**From:** Laura Gibbons <Laura.Gibbons@arun.gov.uk>  
**Sent:** 08 March 2022 16:29  
**To:** Planning.Responses <Planning.Responses@arun.gov.uk>  
**Cc:** David Easton <David.Easton@arun.gov.uk>  
**Subject:** RE: Notification of an Environmental Statement FP/274/21/OUT

Engineers Comments Regarding Surface Water Drainage and Flood Risk

**Application No:** FP/274/21/OUT

**Site Address:** Bognor Regis Golf Club Downview Road Felpham PO22 8JD

Figure 7-1 - SuDS Location Plan

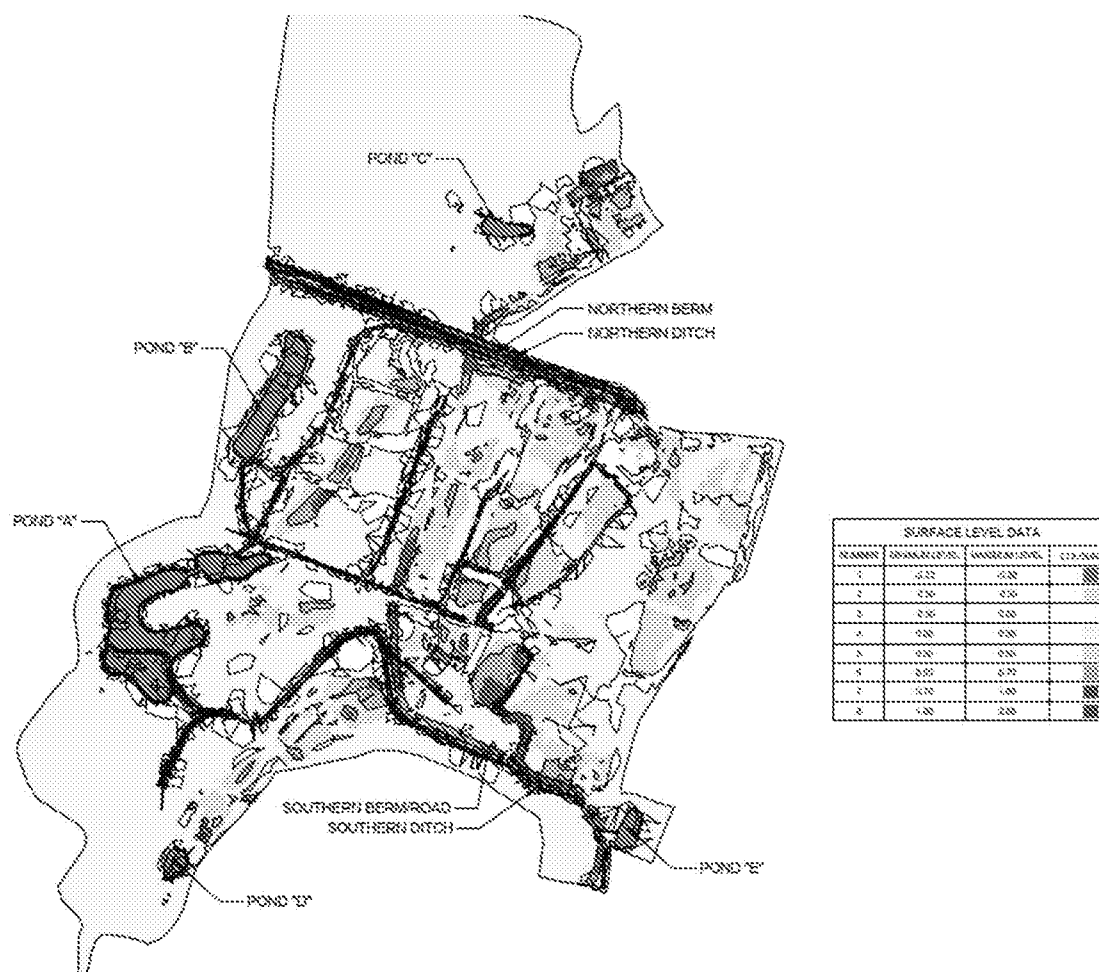
A specific surface water drainage strategy document is referred to but does not appear to be supplied, we only have a surface water drainage strategy document for the proposed golf course. **Please supply the surface water drainage strategy document for the proposed housing development.**

Surface water drainage features must be located outside of areas at risk from flooding. A minimum of a 3m buffer between top of bank of ordinary watercourses and features which will restrict access for maintenance will be required.

SCALE @ A2: 1:2500	CHECKED: B BUTLER	APPROVED: ANDY SMITH
PROJECT No:	DESIGNED: T BUTTON	DRAWN: T BUTTON DATE: December 21
DRAWING No: XXX-WSP-XXX-XXX REV: P01

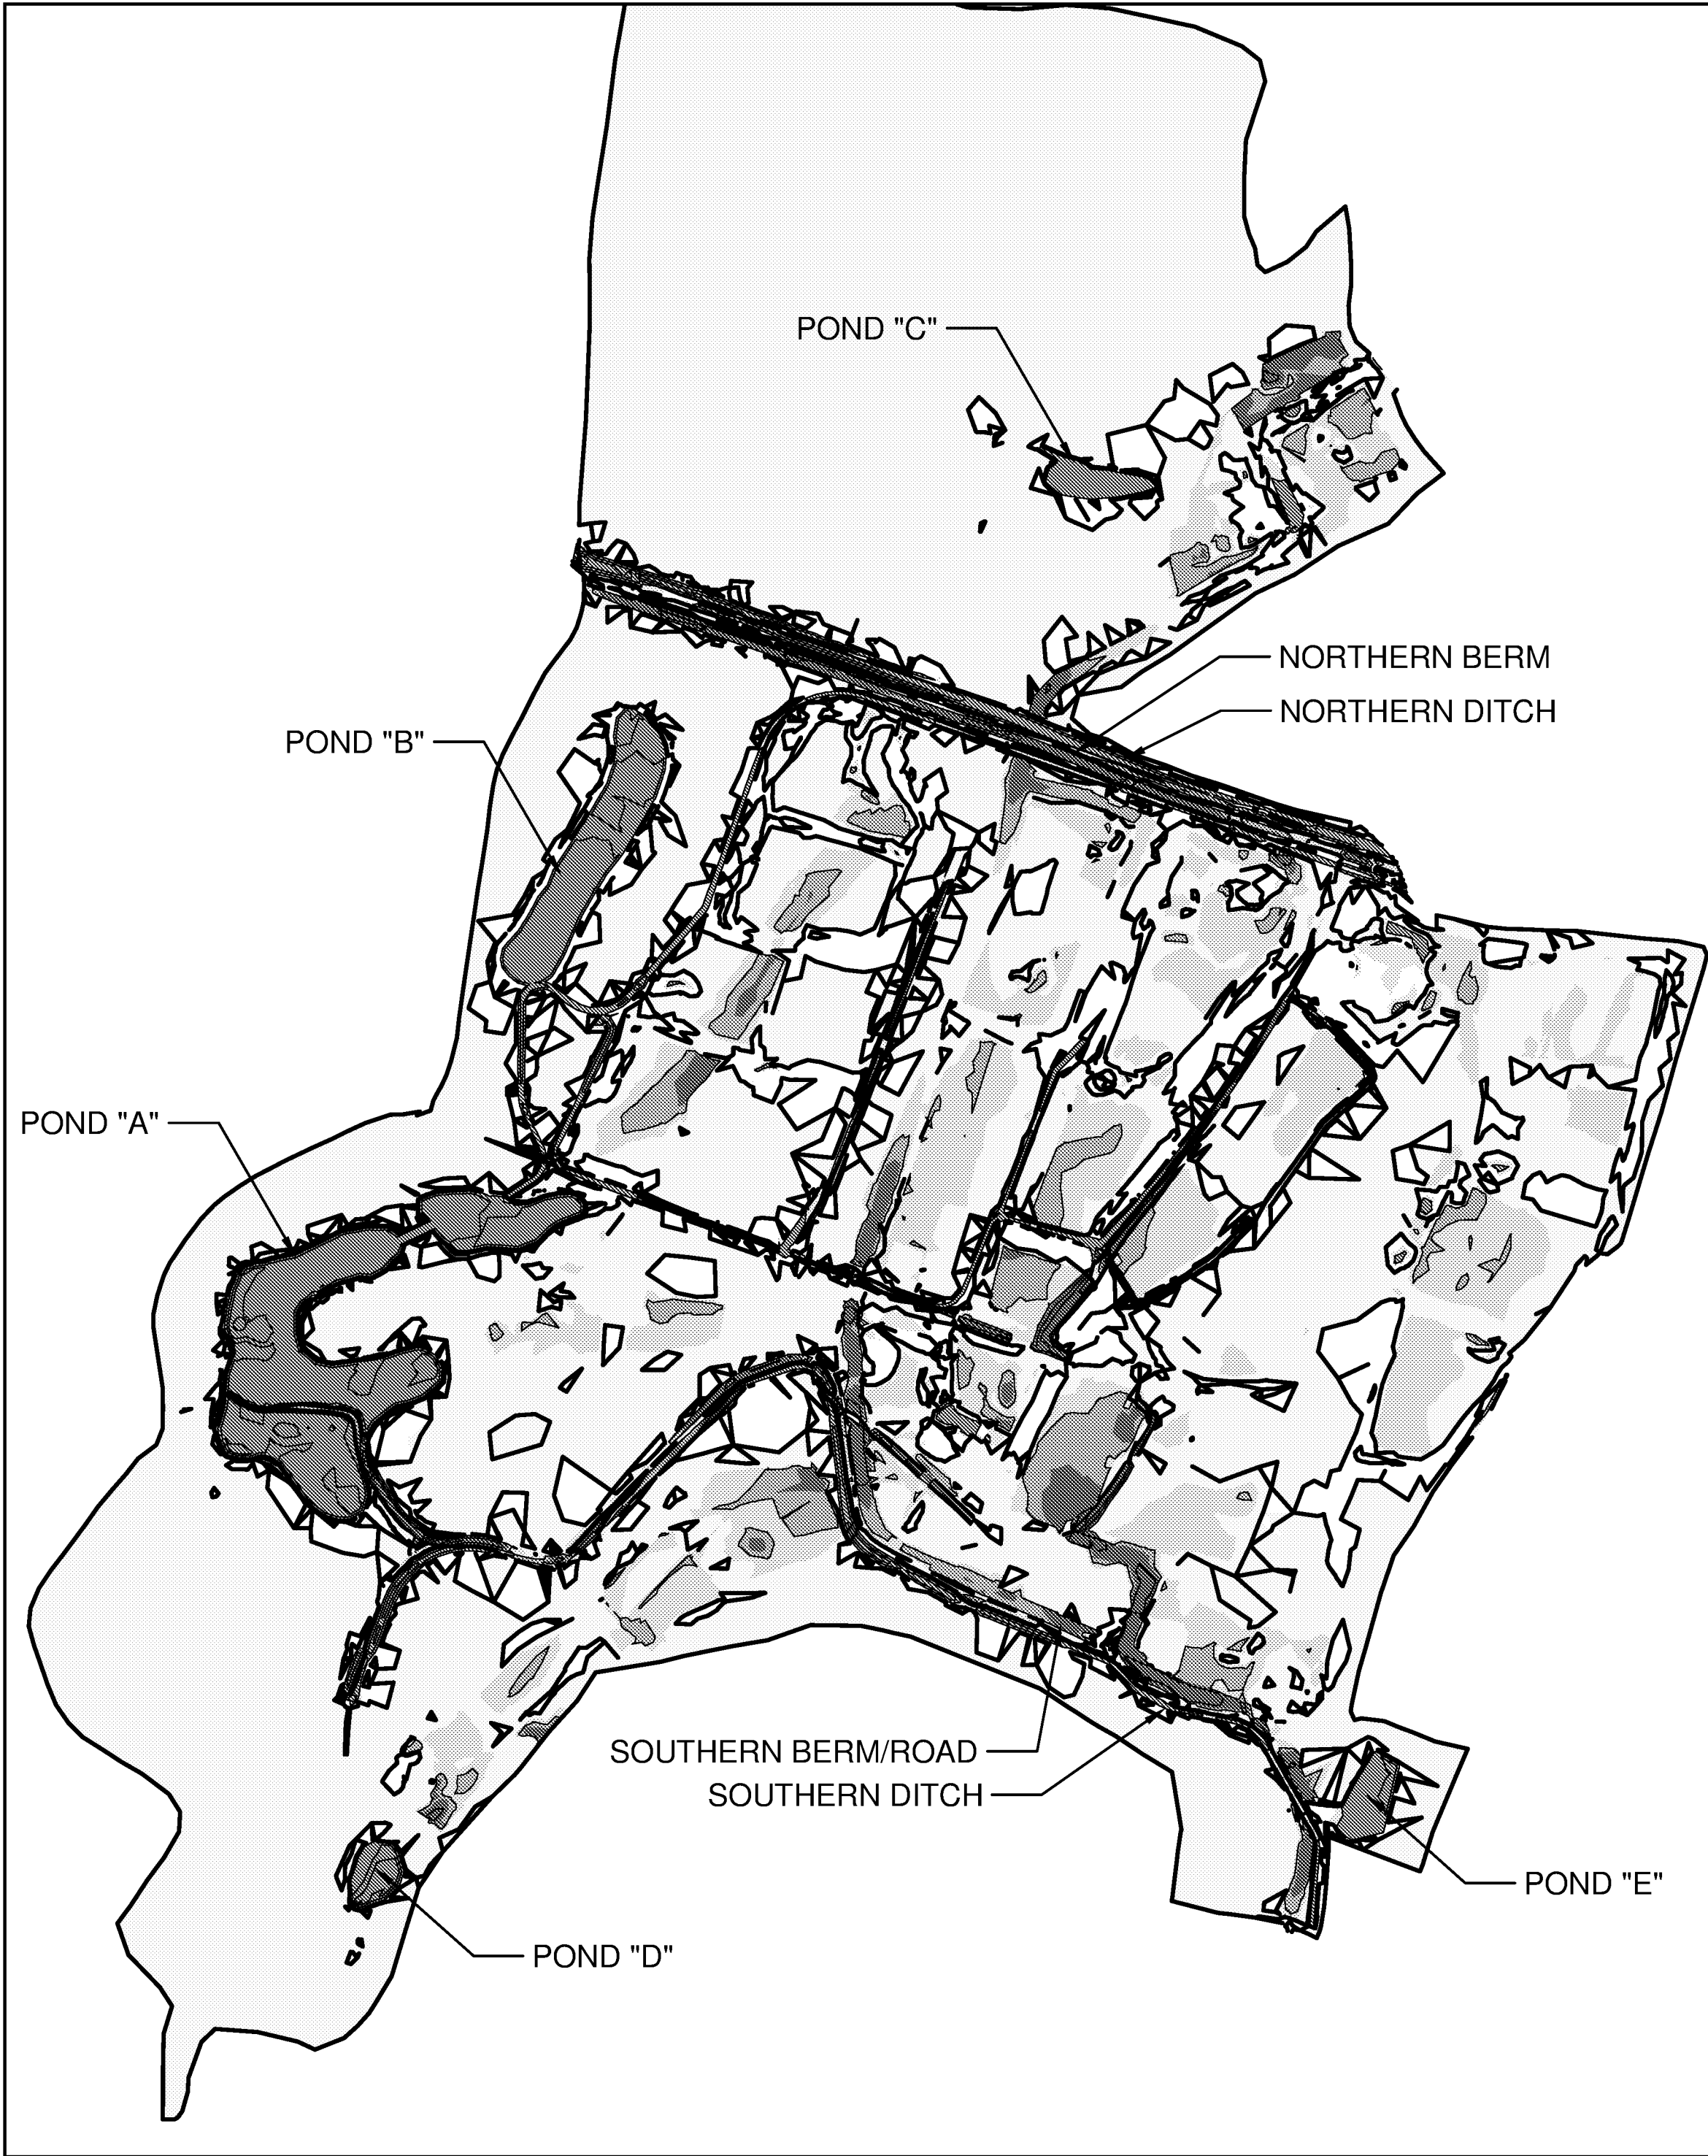
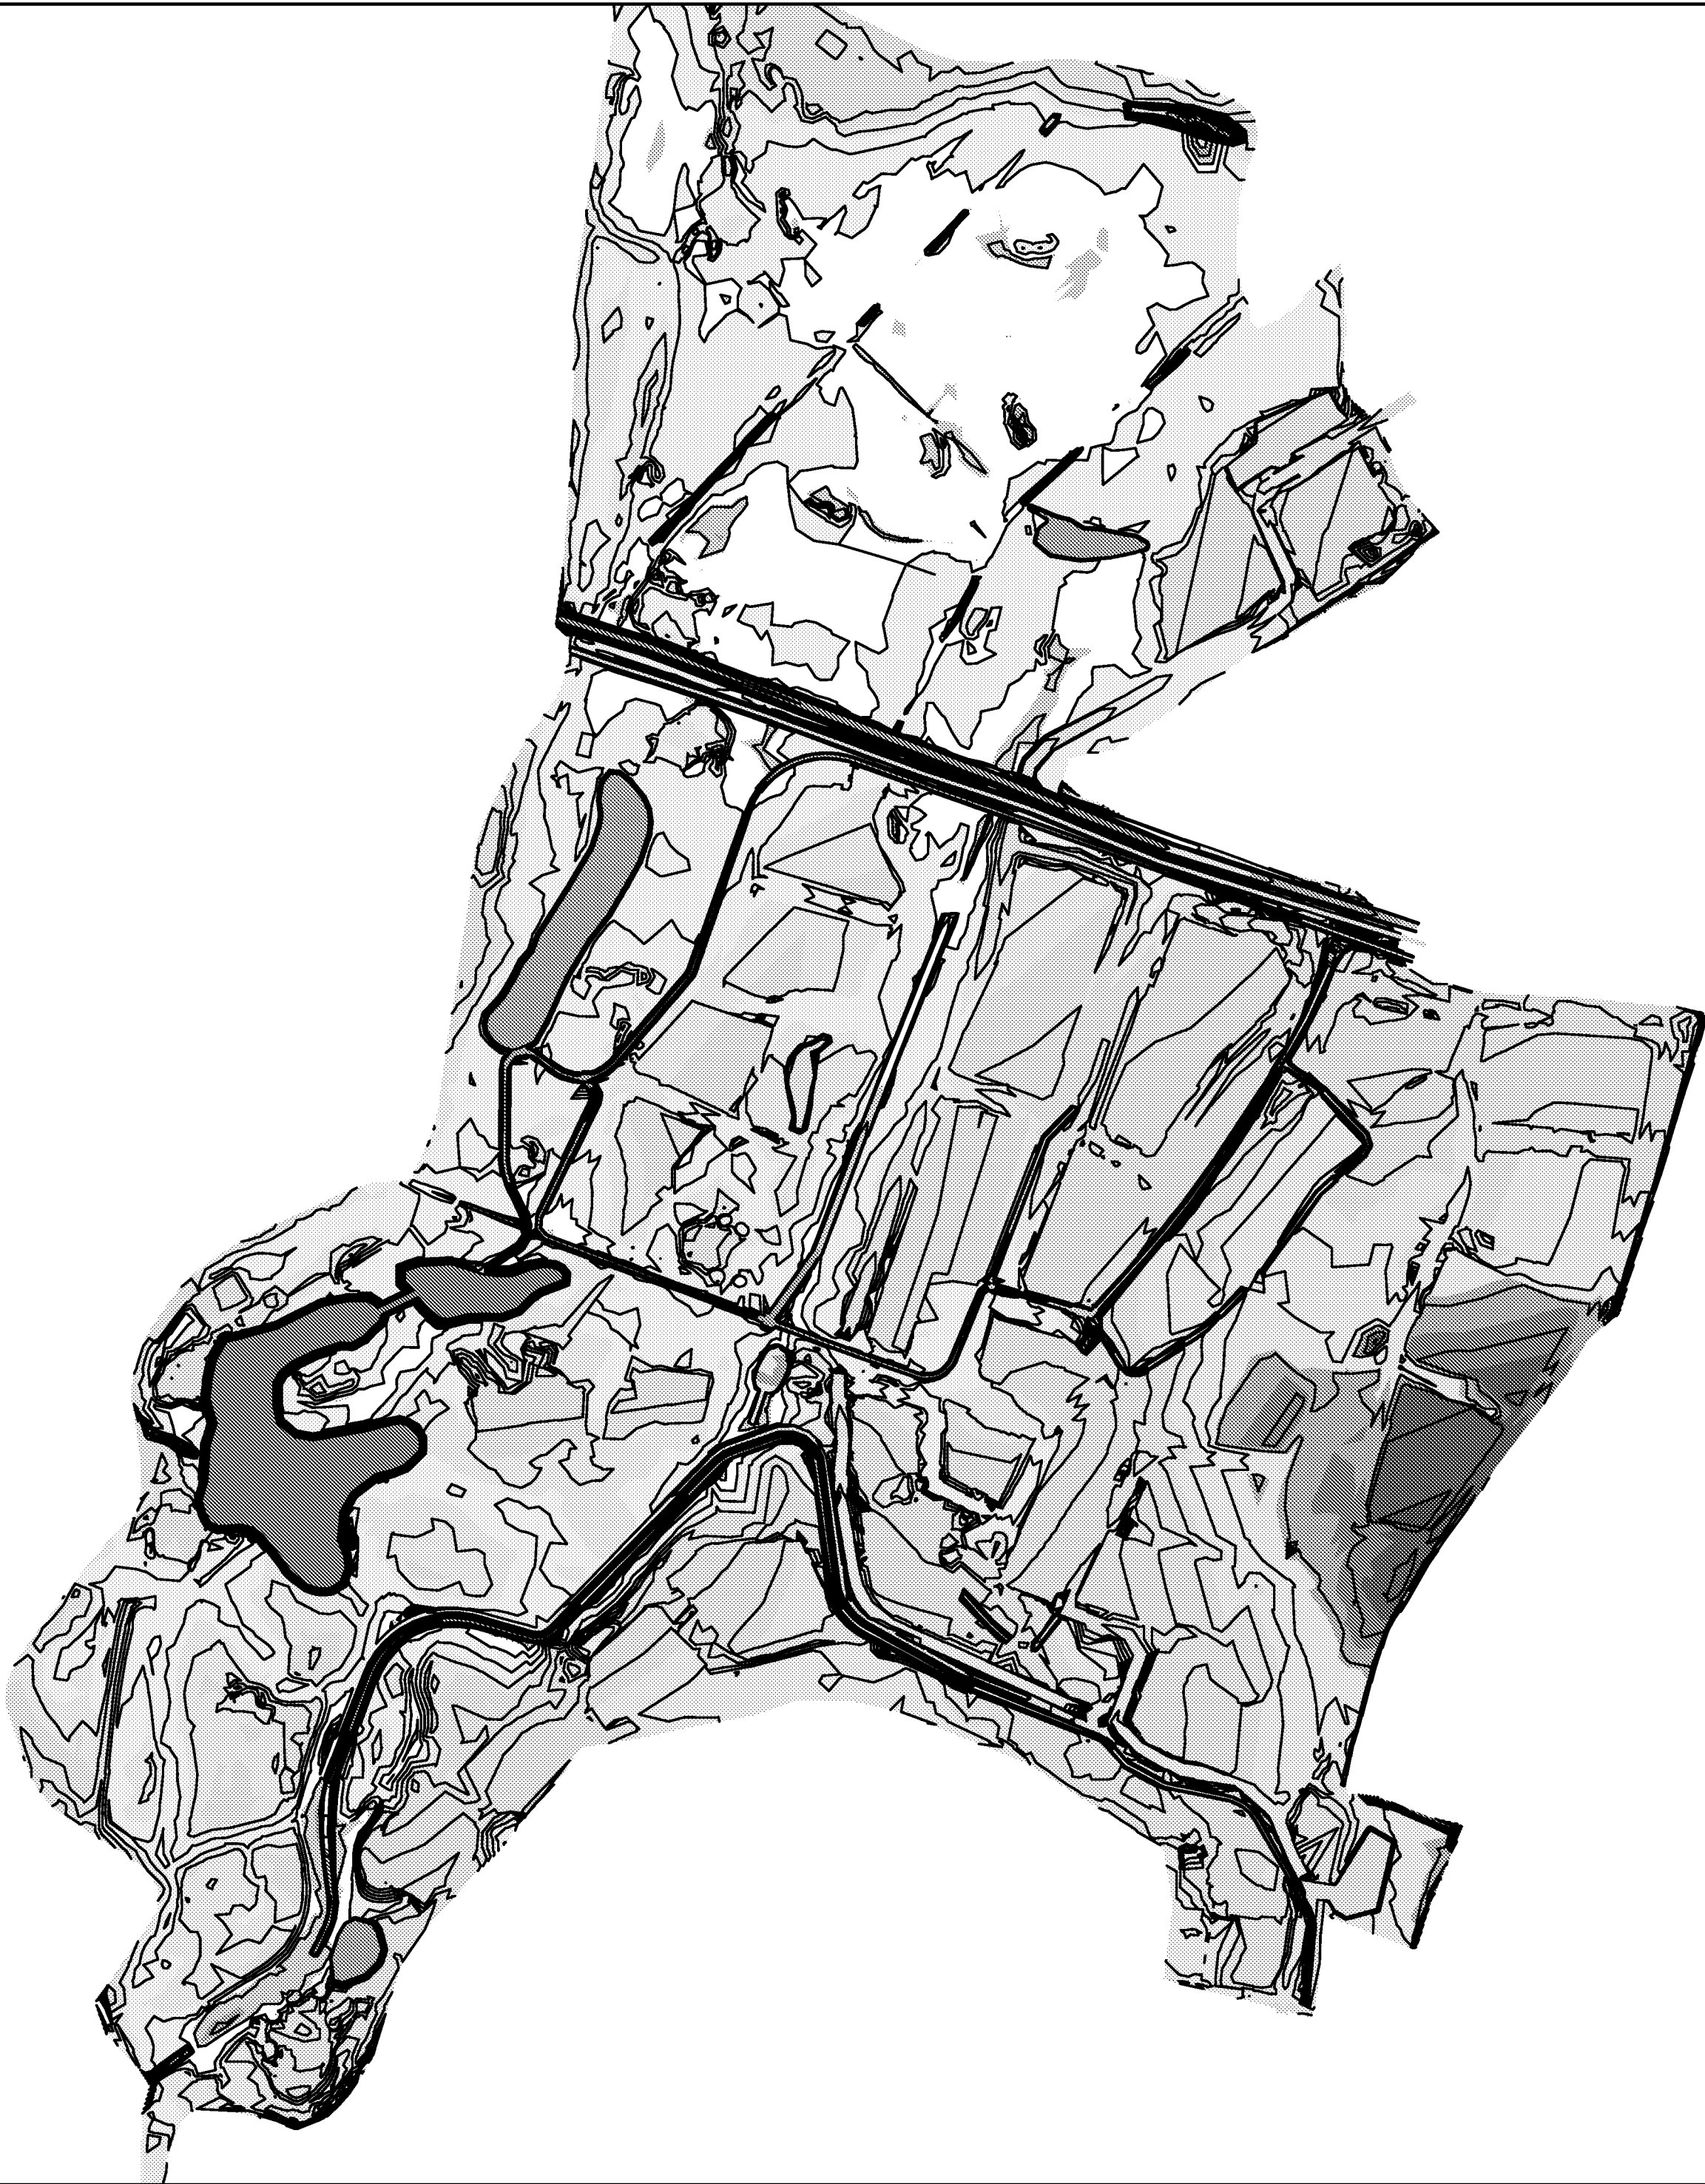
It appears that it is proposed to raise ground levels, ground raising is discouraged. If it is considered absolutely necessary, then due consideration must be given to the potential impacts on existing properties adjacent the development site, in terms of possible elevated groundwater levels and surface water run-off implications.
